Case Officer: George Smith

Recommendation: Refuse

Proposal: Erection of an agricultural barn store (re-submission of 20/03347/F)

SKETCH VIEW IMPRESSION OF PROPOSED BARN FROM THE WEST

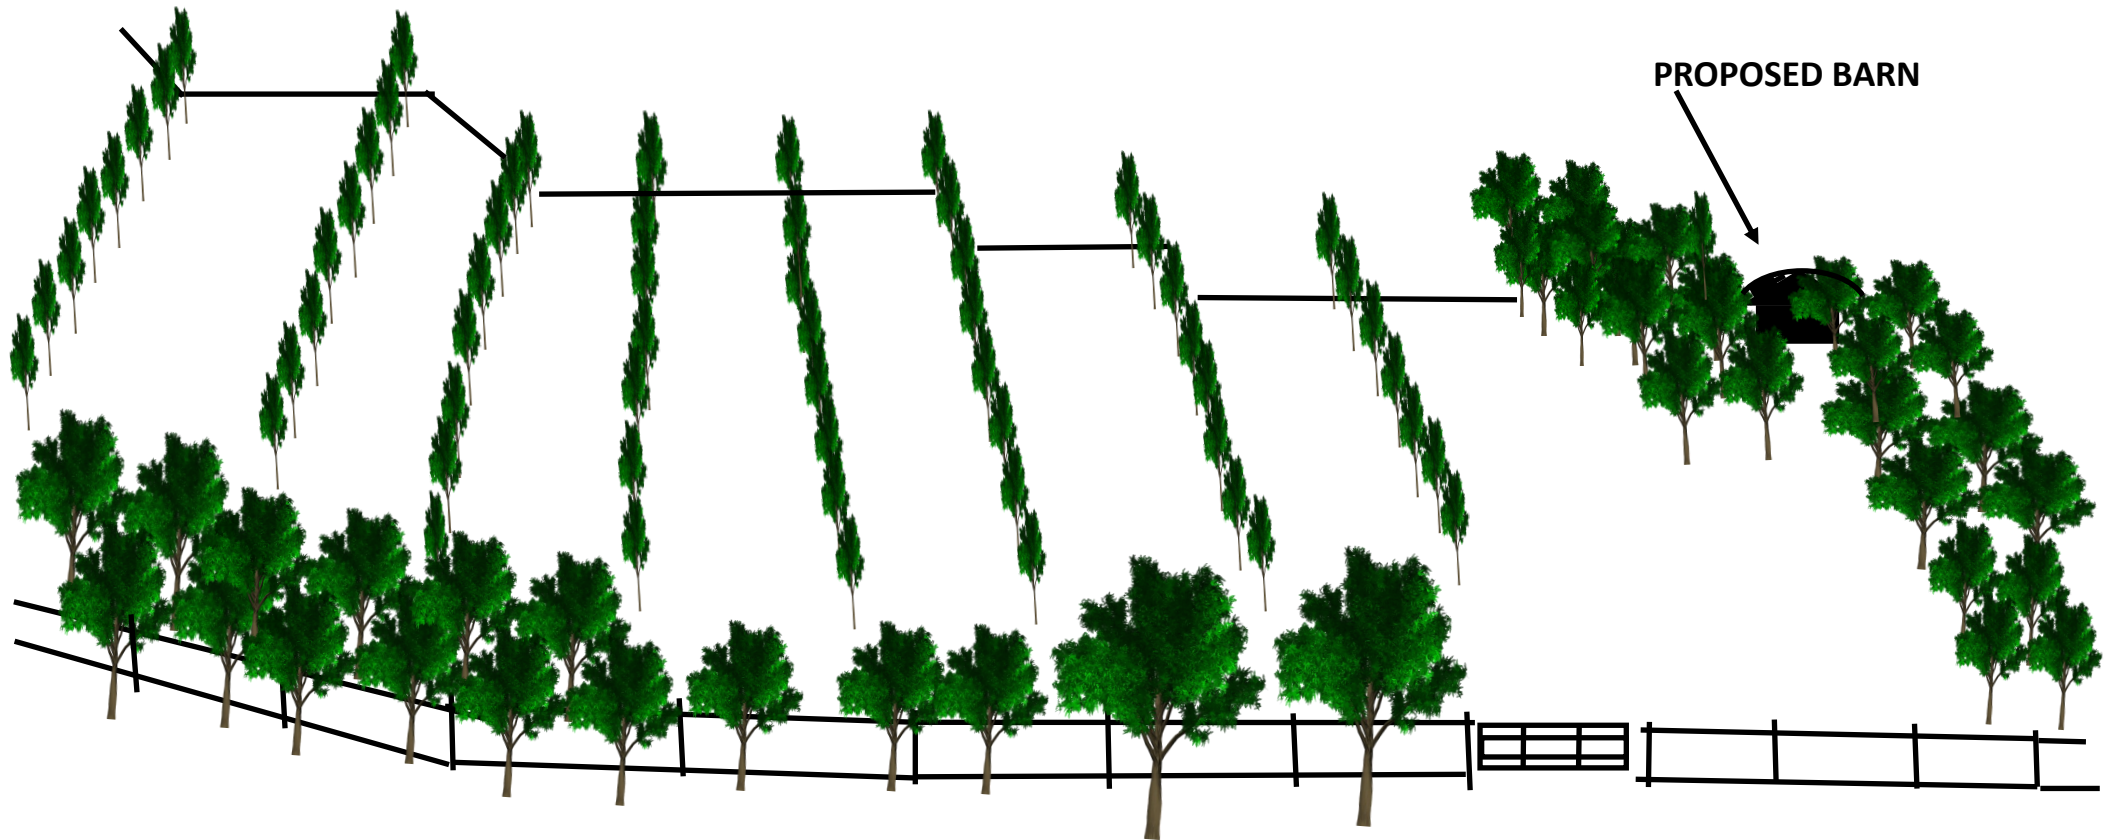
- 2.1. The applicant seeks the erection of a new barn. The barn would have a floor area of 36sqm (9m x 4m) with a height of 4m. It has not been clarified at this stage what materials the barn would be constructed in externally. The barn would have a 'Dutch barn' style roof.
- 2.2. The applicant states that they are in the process of cultivating and planting the land to form a small Vineyard an Apple Orchard and that they are also intending to bottle water from their Natural Spring. They state that the building is required for the ventures, as follows:
 1. To Store Agricultural Plant and other associated paraphernalia that would be used in the maintenance of the Vineyard and Orchard.
 2. To House Vats, Processing Equipment and Bottling Systems for Wine, Spring Water and Cider.

- 3) *Design* – the building as proposed appears to be of an appropriate design for its intended use, however no material details have been submitted so we cannot make a full assessment in terms of its impact on the character of the area.

- 4) *Scale* – The scale of the building appears reasonable for the proposed use, however there are considered to be concerns with regard to its impact on the character of villages and the surrounding environment.

- 8.23. The Conservation Officer (CO) has objected to this application as it stands. The CO notes the sensitive location of the site, with landscaping works and removal of trees (unauthorised, but primarily outside the application site) making the site more visible within the Conservation Area. The CO notes that no justification has been provided for the siting of the barn in this location. The CO concludes that the location, scale and design of the barn would cause harm to the character and appearance of the Conservation Area. Planning officers concur with the CO's advice and consider that the proposal, in terms of its scale and siting, would amount to significant and demonstrable harm to the character and appearance of the Conservation Area.

- 8.24. Officers also note that the applicant has not clarified the materials to be used externally. Whilst this matter could potentially be controlled by condition, the uncertainty is a concern carried forward in the assessment of this application as it stands.

1. The proposed building, by reason of its form, scale, appearance and prominent siting within the Sib Valley in open countryside, would cause significant visual intrusion and would adversely affect the undeveloped character, attractive qualities and appearance of the landscape of the Sib Valley and would cause harm to the character and appearance of the Sibford Gower with Burdrop Conservation Area. It has not been demonstrated that there is an essential need for the building in this location and insufficient information has been received in order to assess the viability of the proposed business use, and therefore the identified harm significantly and demonstrably outweighs any benefits arising from the proposal. The proposal therefore fails to accord with Policies ESD1, ESD13 and ESD15 of the Cherwell Local Plan (2011-2031 Part 1), Saved Policies AG2, C23, C28 and C33 of the Cherwell Local Plan (1996) and relevant paragraphs of the National Planning Policy Framework.
